Medworth CHP Limited DCO application

Planning Inspectorate Reference: EN010110

Summary of Written Representation, Cambridgeshire County Council and Fenland District Council

**Figure 10.1i**  
**New Bridge Lane access design**

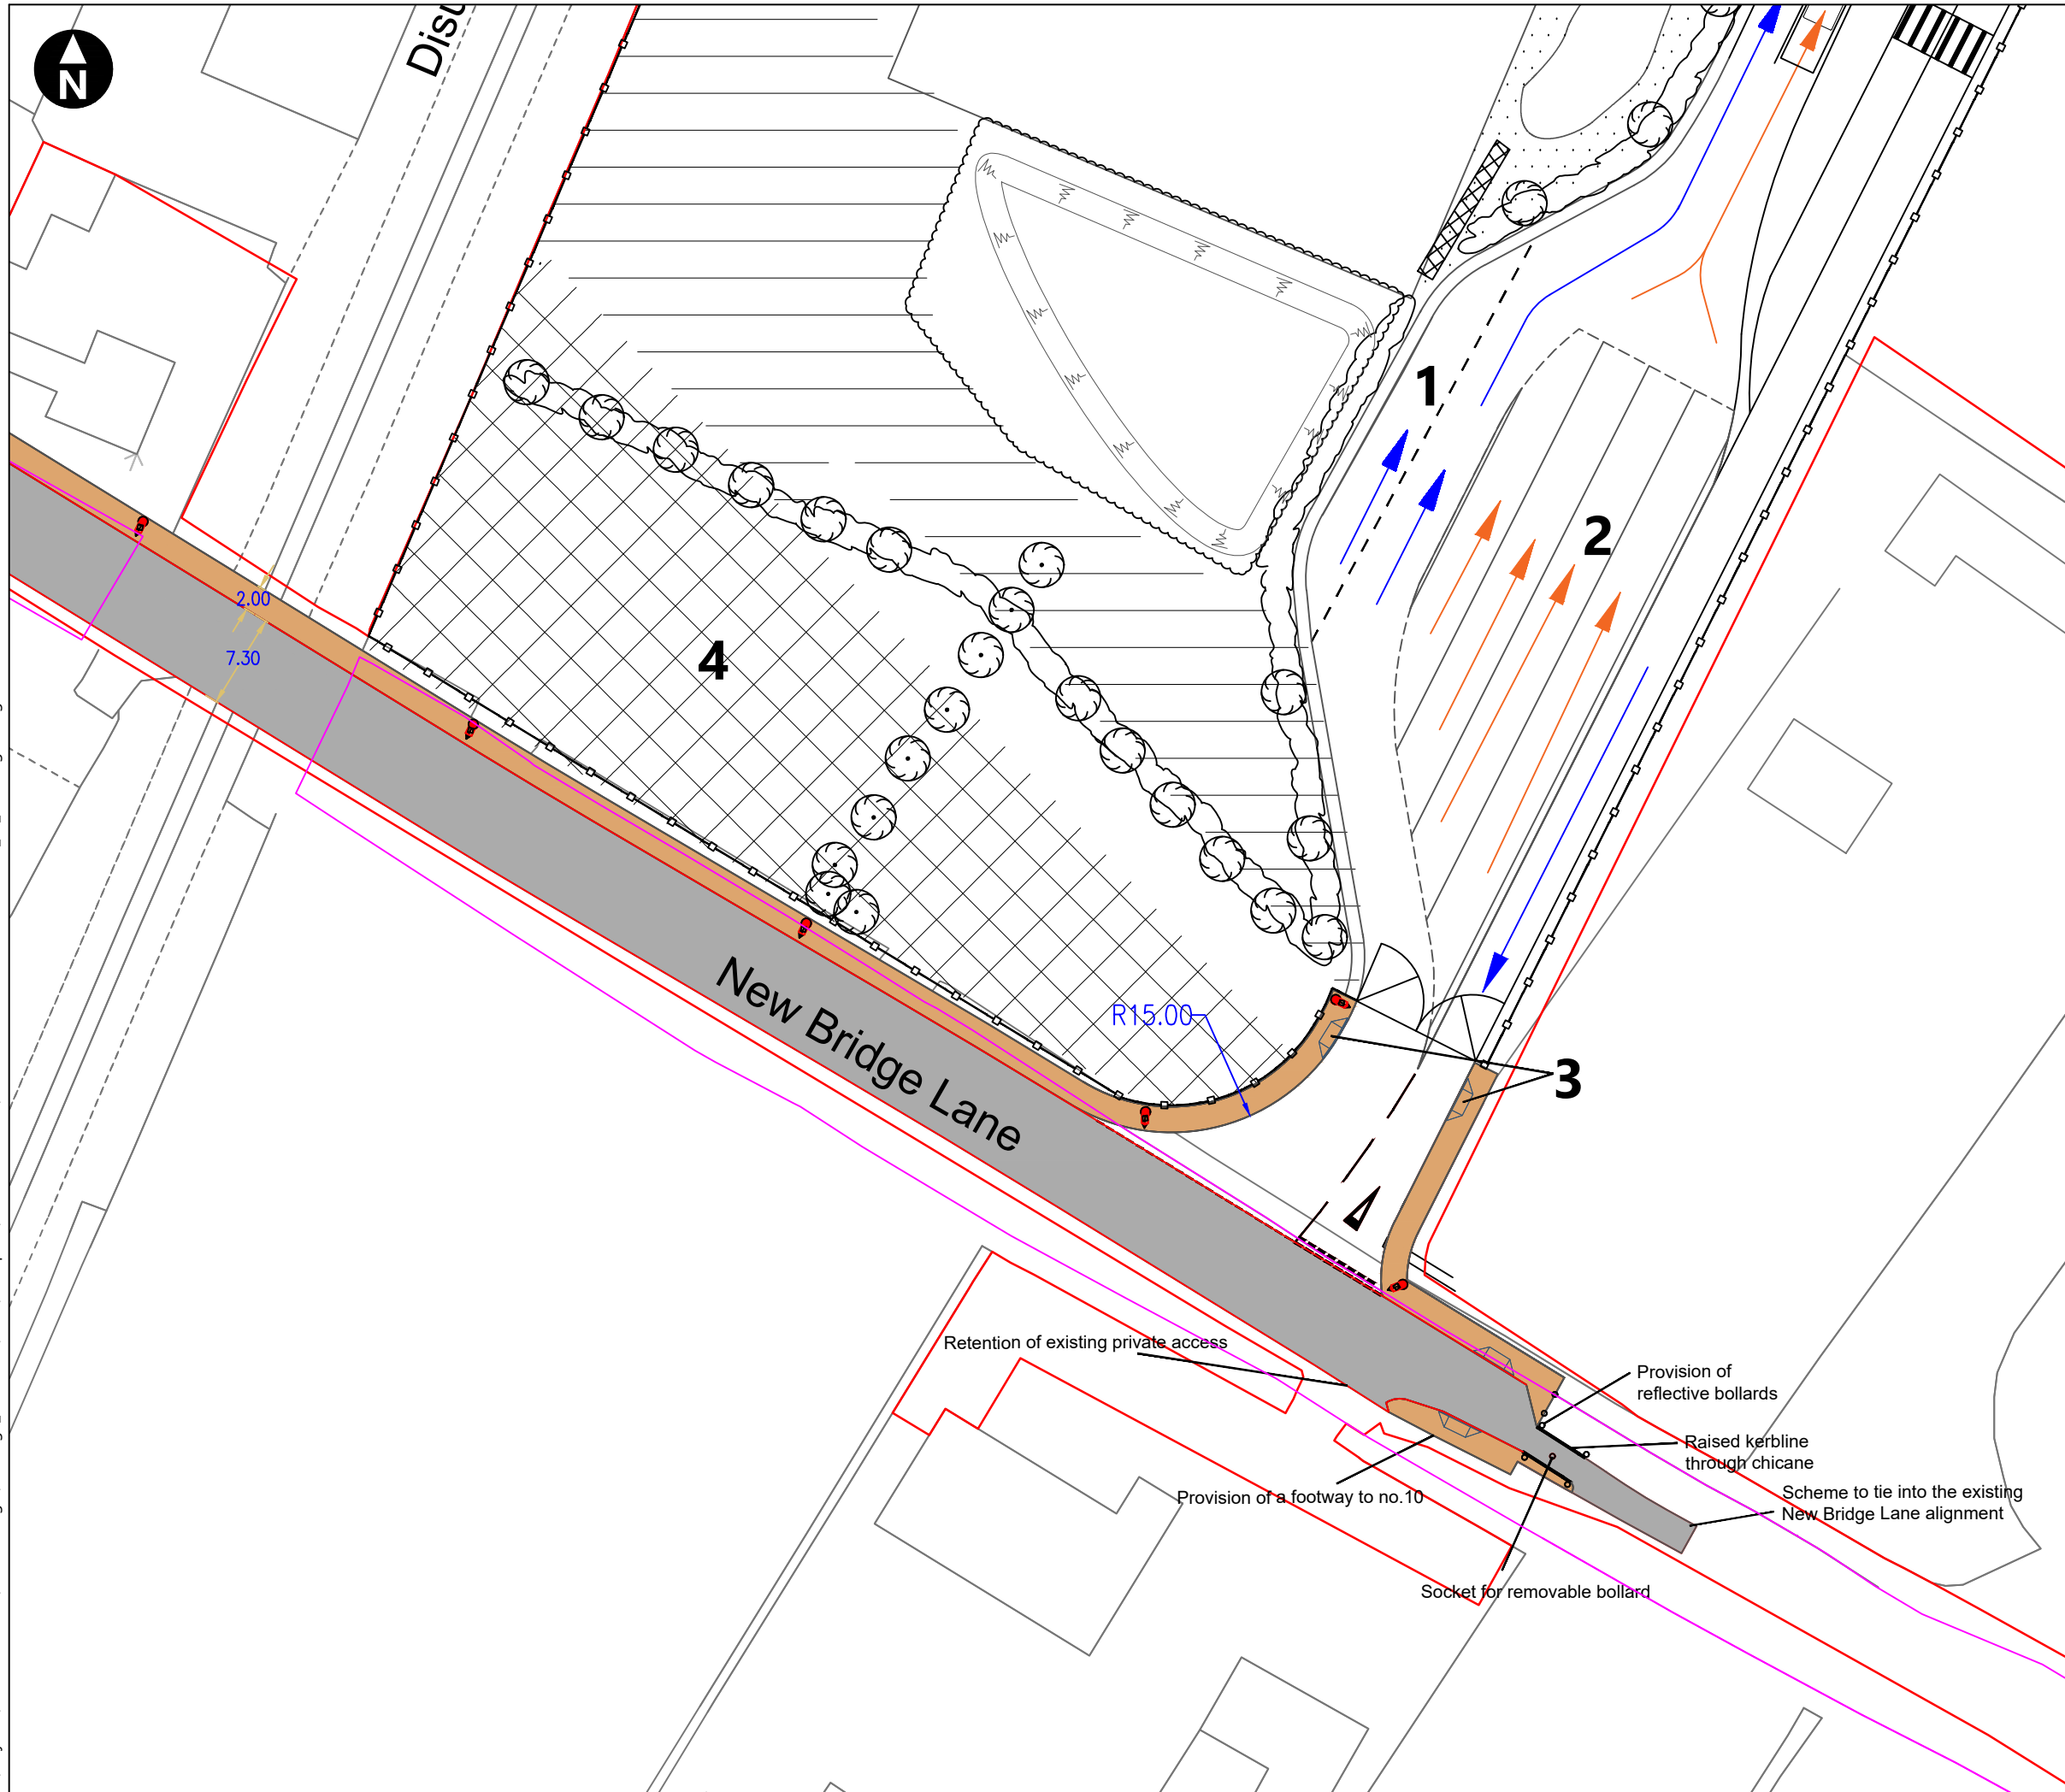
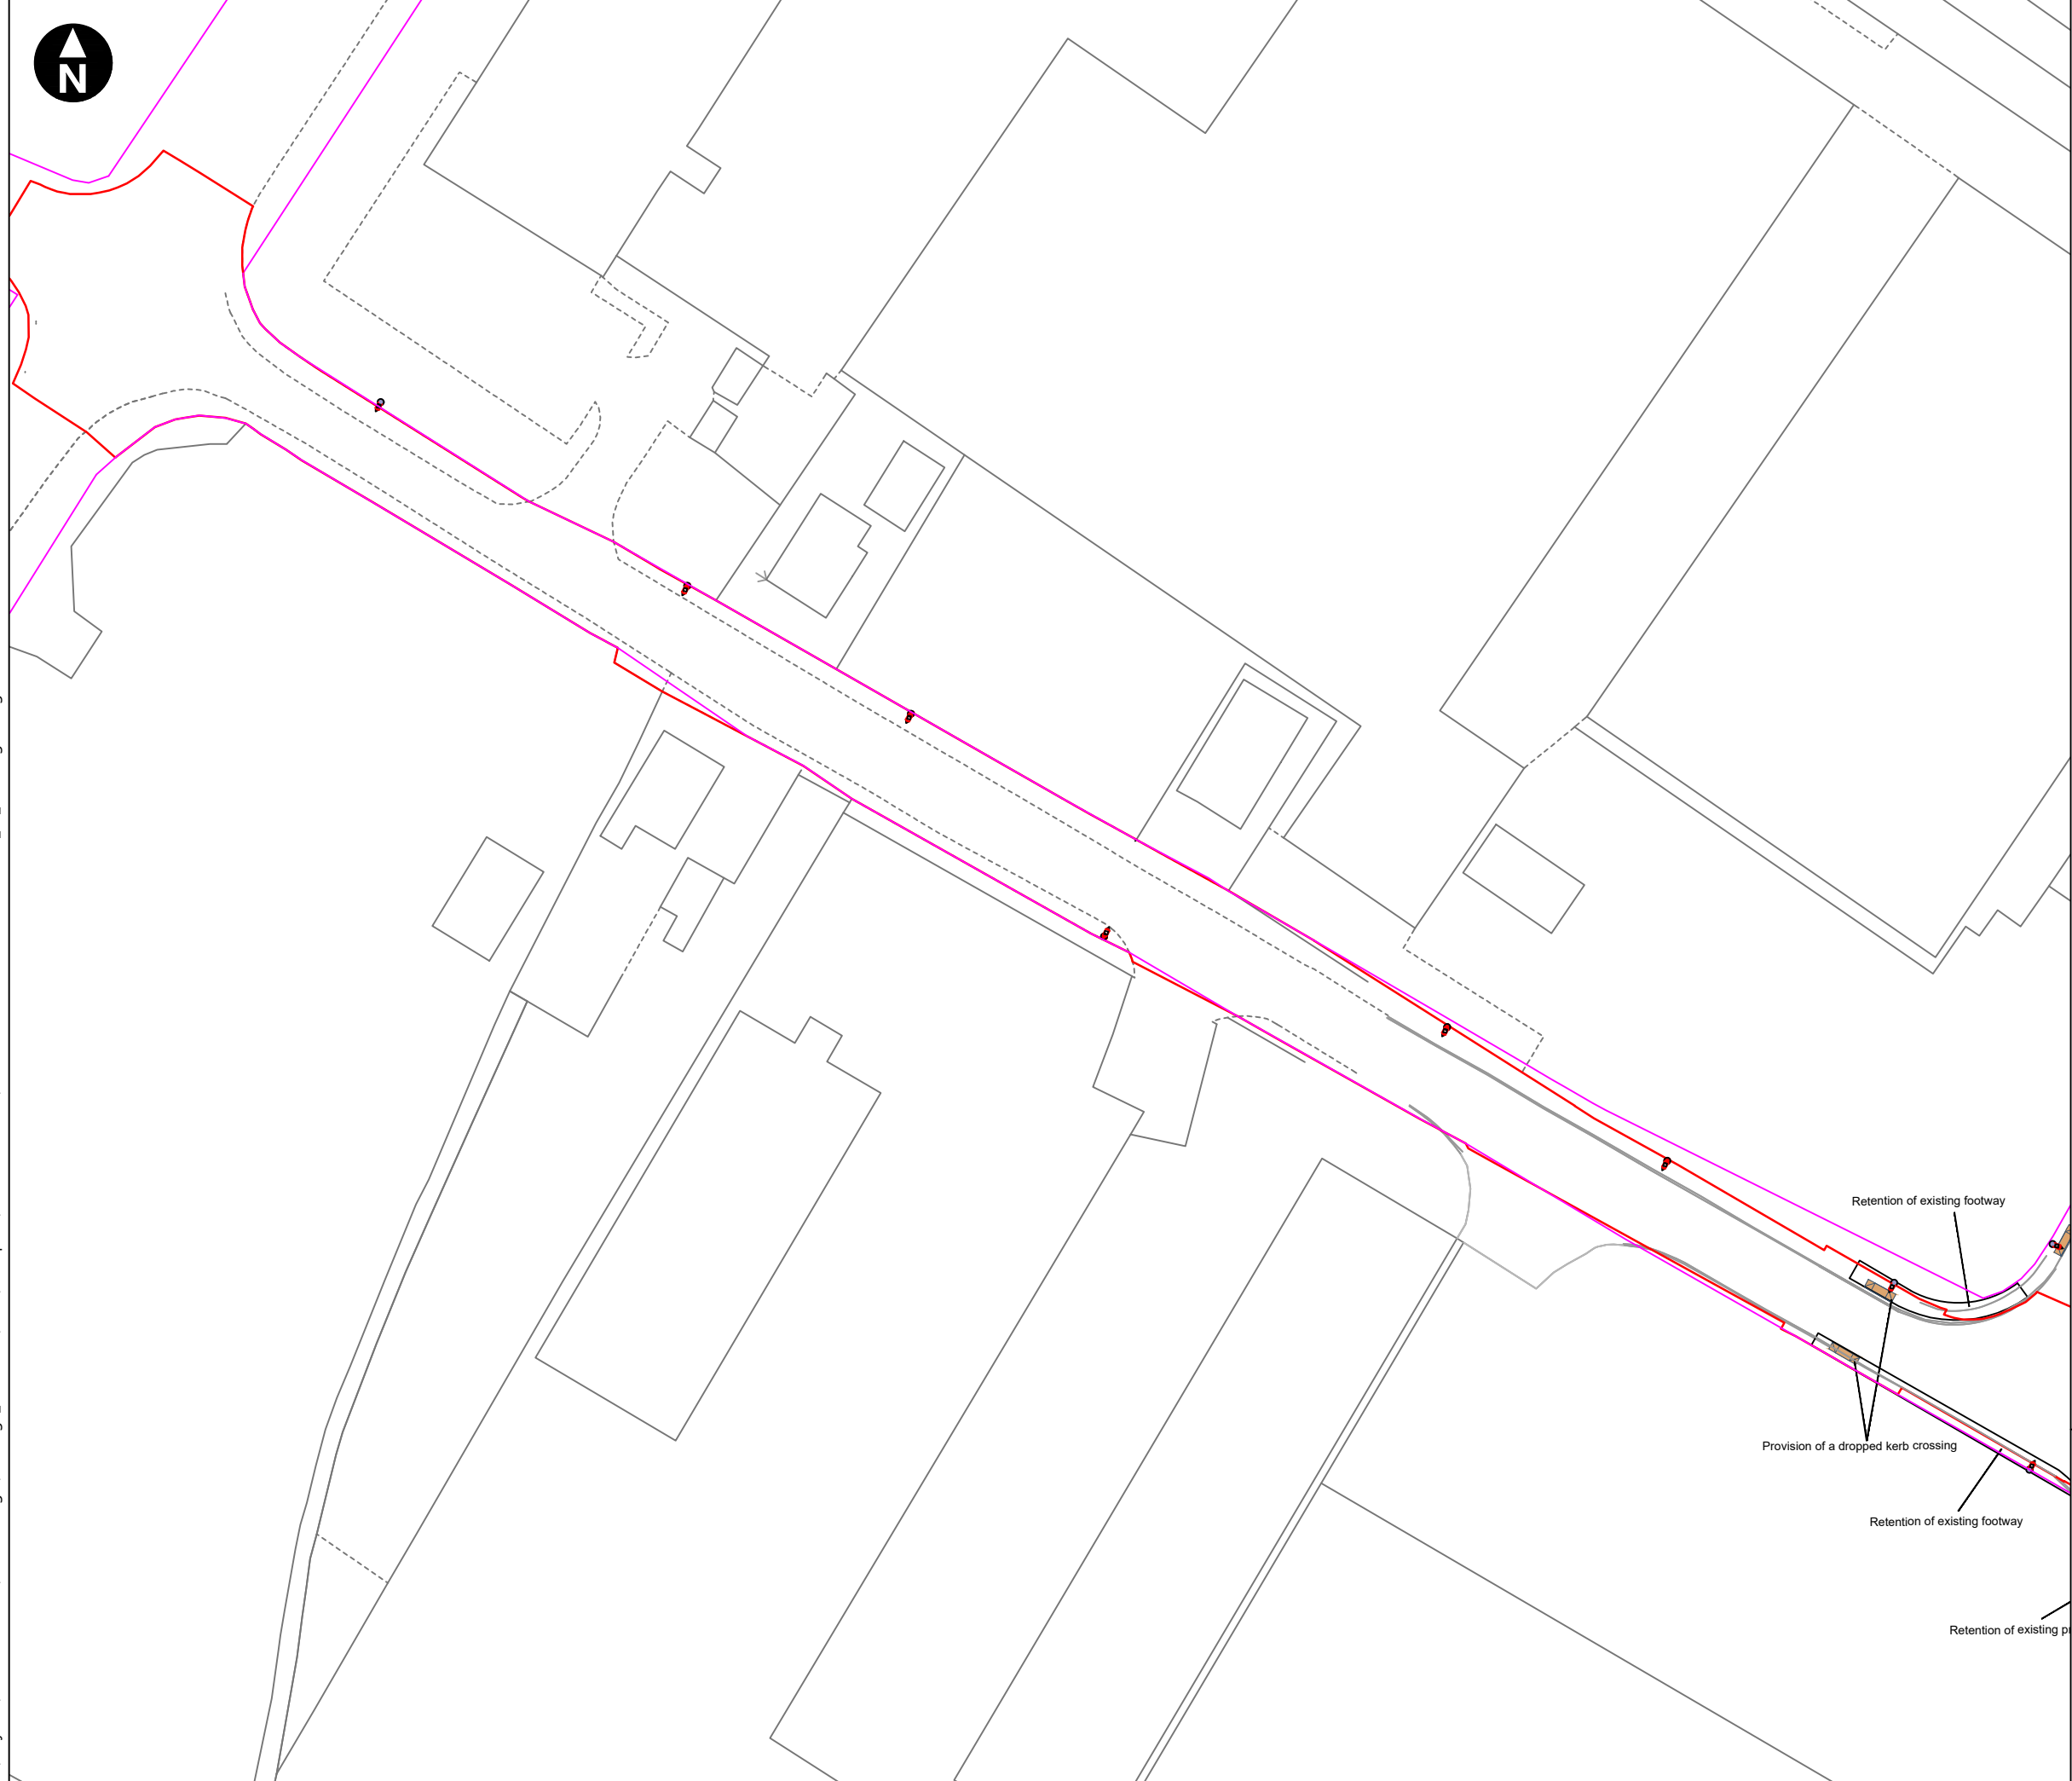
- 4.4 There is insufficient land available along New Bridge Lane to achieve a wide enough access road for the facility, as stated in 2.7.19 of the LIR.

**Figure 10.1iv**  
**Cromwell Road/New Bridge Lane Signal Scheme - General arrangement**

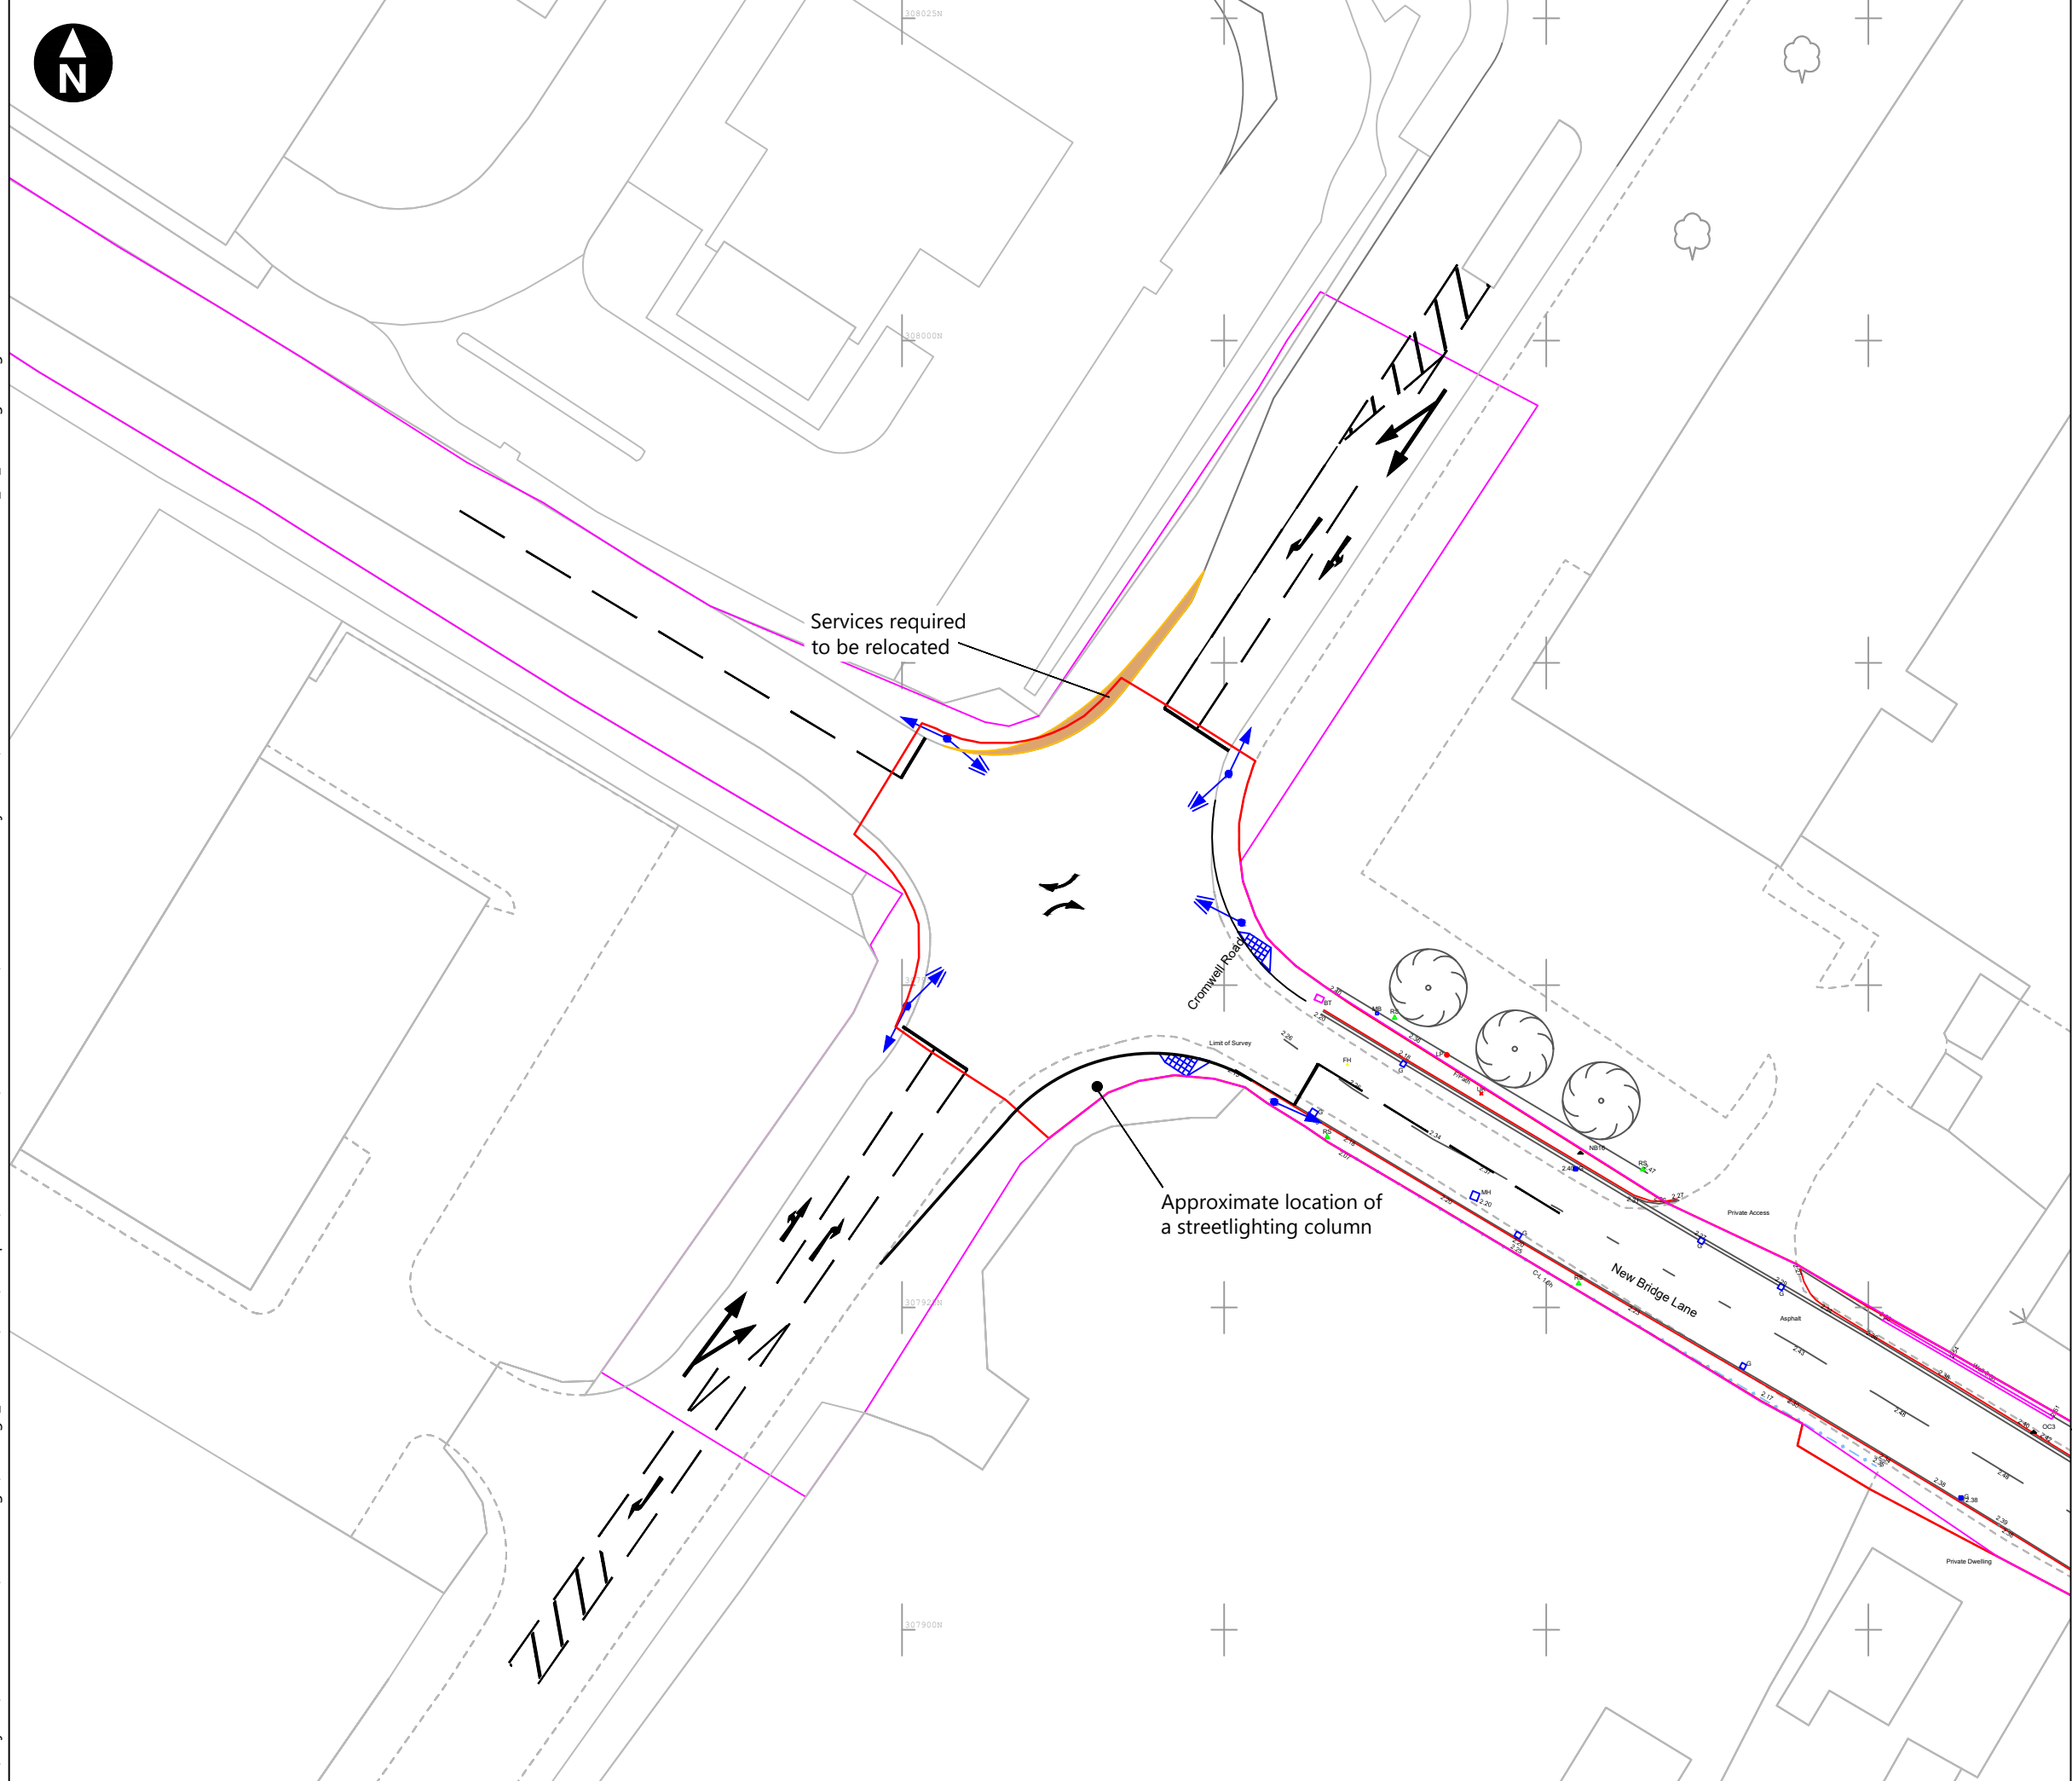
- 5.1 CCC's Signals and Safety Audit Team are concerned by the impact of the proposal on the Cromwell Road/New Bridge Lane Junction and consider that an acceptable form of junction design may not be achievable within existing highways constraints, the access to the scheme would be unsafe, thus rendering the proposal unacceptable.
- 5.2 The proposed development may have traffic implications that have not yet been fully assessed.
